Ribble Valley Borough Council
Planning Department
Planning Application No: 3/2023/0271
Location: 3 Fort Street

I write with reference to the amended proposed plans for 3 Fort Street, submitted 2nd May 2023. Whilst I appreciate the decrease of 70 centimetres in the length of the extension, I continue to have concerns as noted in my previous letter dated the 1st May 2023.

6866 -P01B

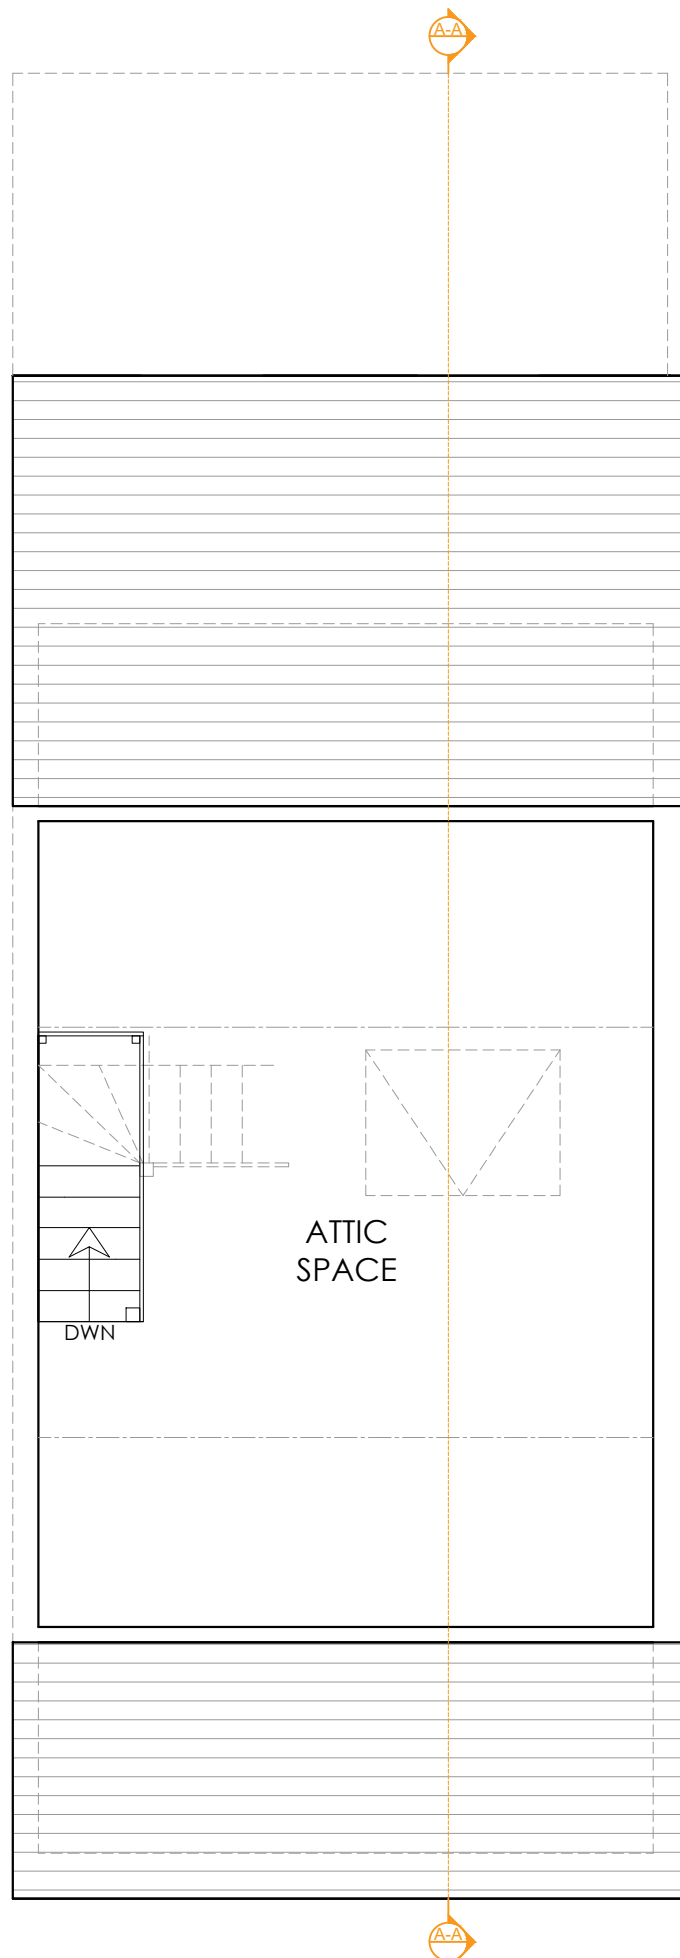
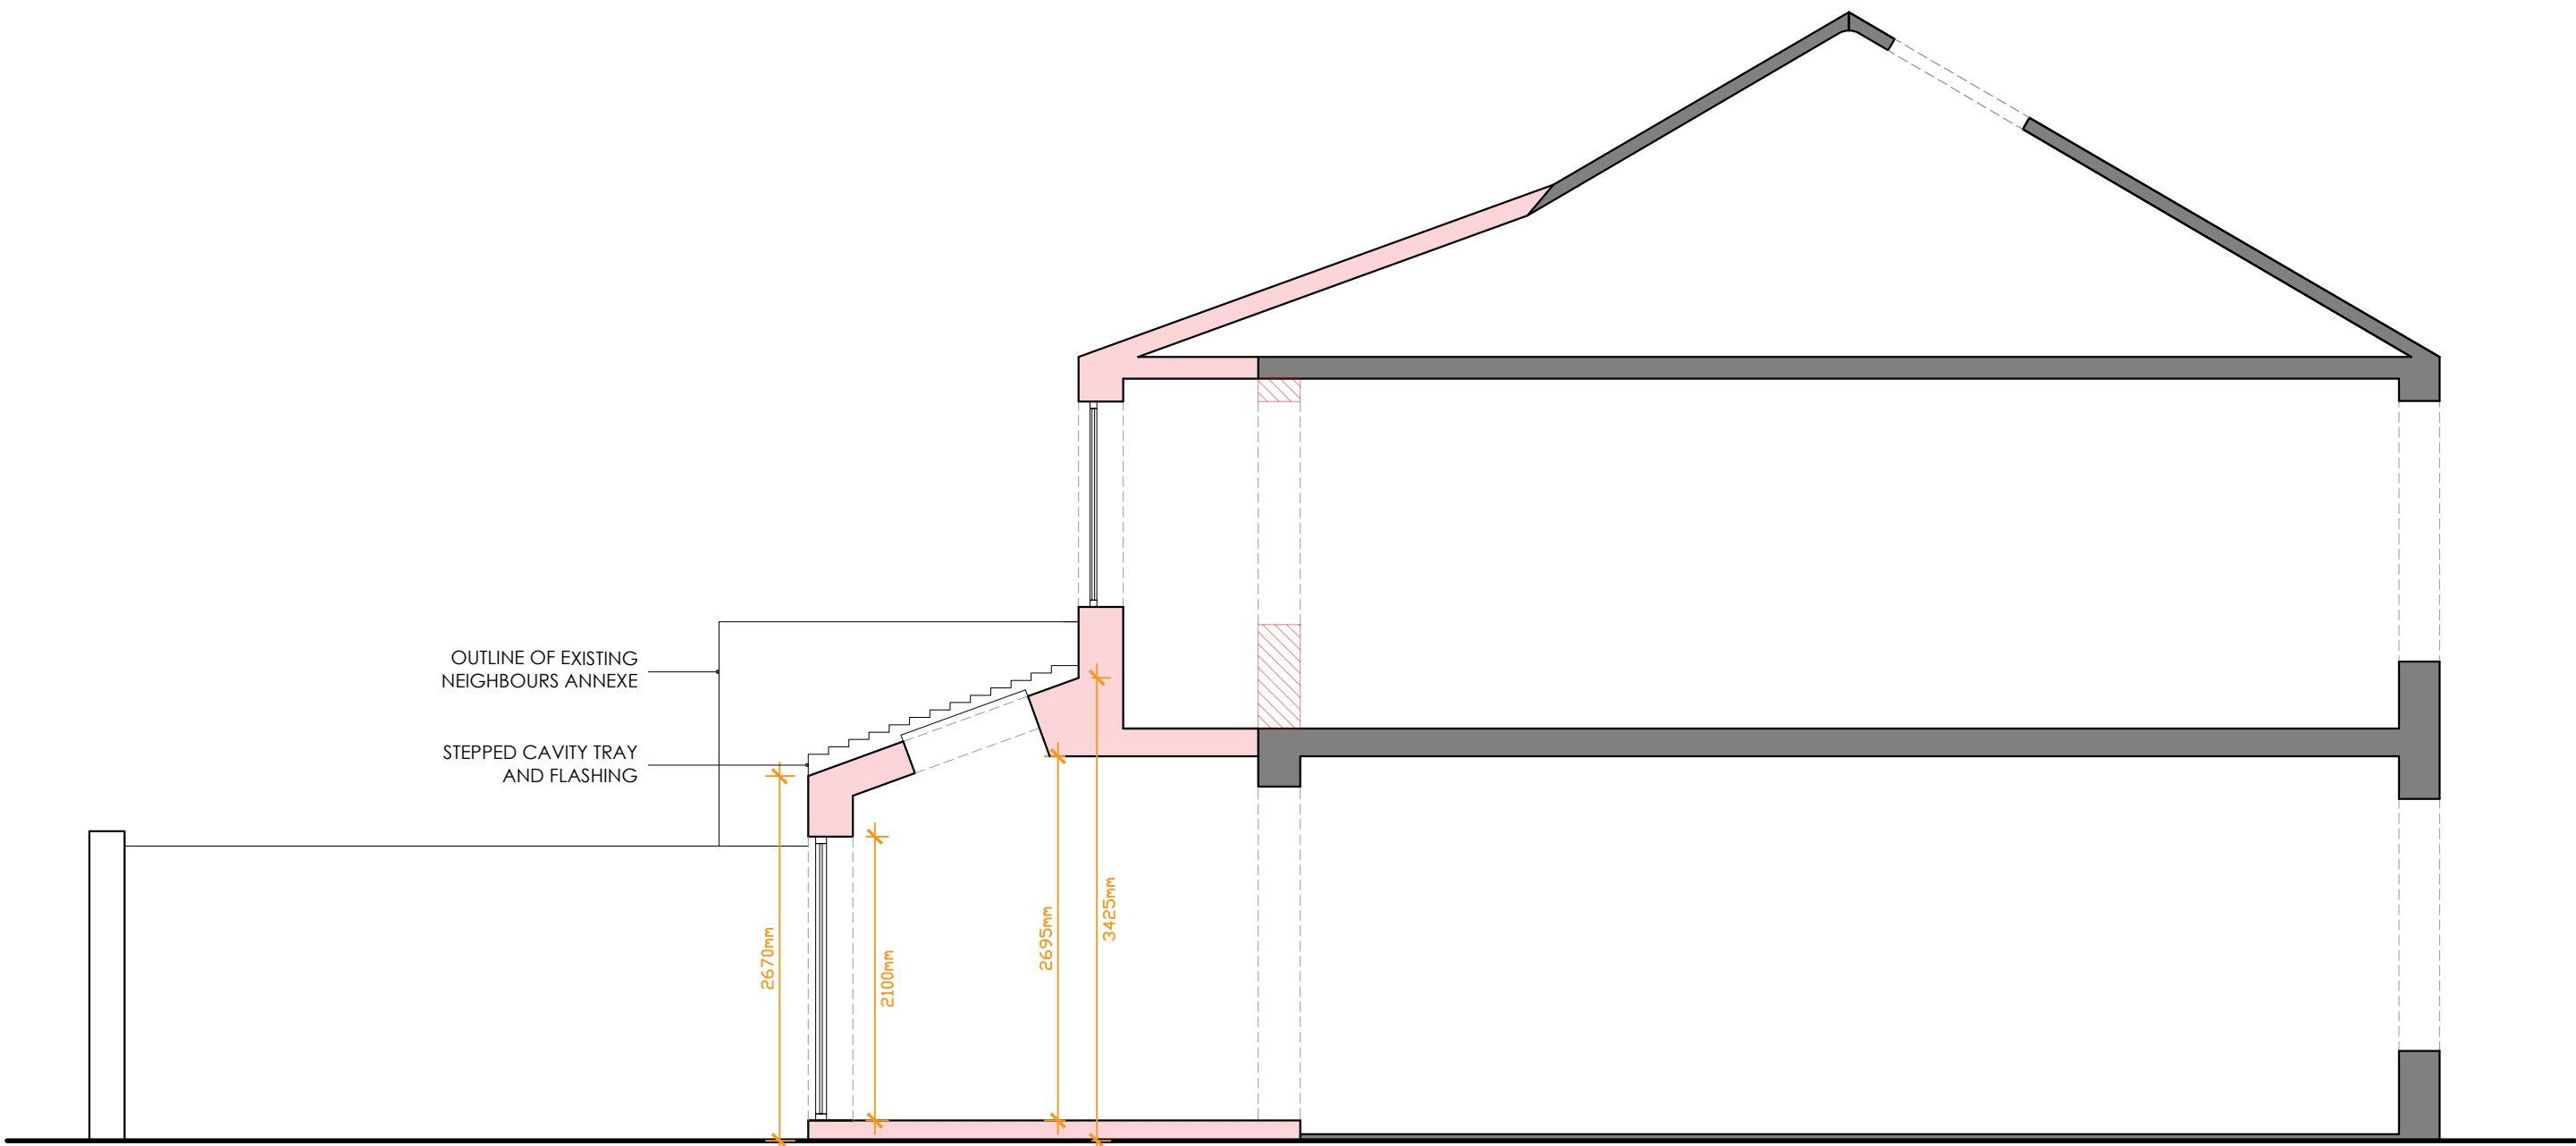
Again, I believe assessments are required to evaluate the potential impact to loss of daylight/sunlight to the rear of 3 Fort Street along with possible overshadowing and dominance of the proposed extension.
